**Application by National Highways for an Order granting Development Consent for
The Lower Thames Crossing**

**SUMMARY OF WRITTEN REPRESENTATION
SUBMITTED ON BEHALF OF
ST. MODWEN DEVELOPMENTS LIMITED
(PLANNING INSPECTORATE REFERENCE:
20035817)**

E. Work No. 9Z (Sheet 66) – Walking, Cycling, Horse Rider bridge over A127

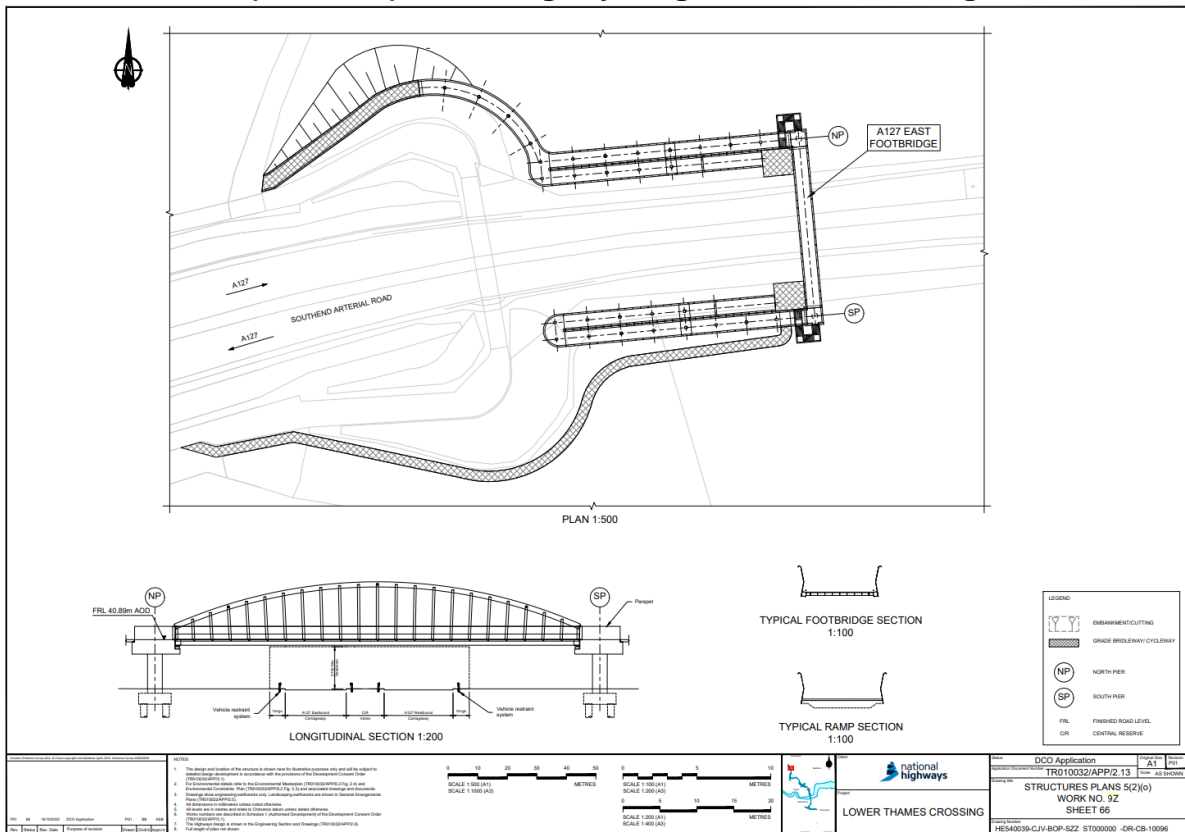
- 7.2 The delivery of a proposed LTC bridge for walkers, cyclists and horse riders over the A127 is fundamentally incompatible with the proposed delivery of the new BEP A127 bridge. The draft DCO also proposes the unjustified compulsory acquisition of the land required for the BEP A127 bridge. The Applicant has acknowledged the importance of preserving the delivery of the BEP A127 bridge but its proposed approach of dealing with this through the Design Principles [APP-516] is wholly inadequate.
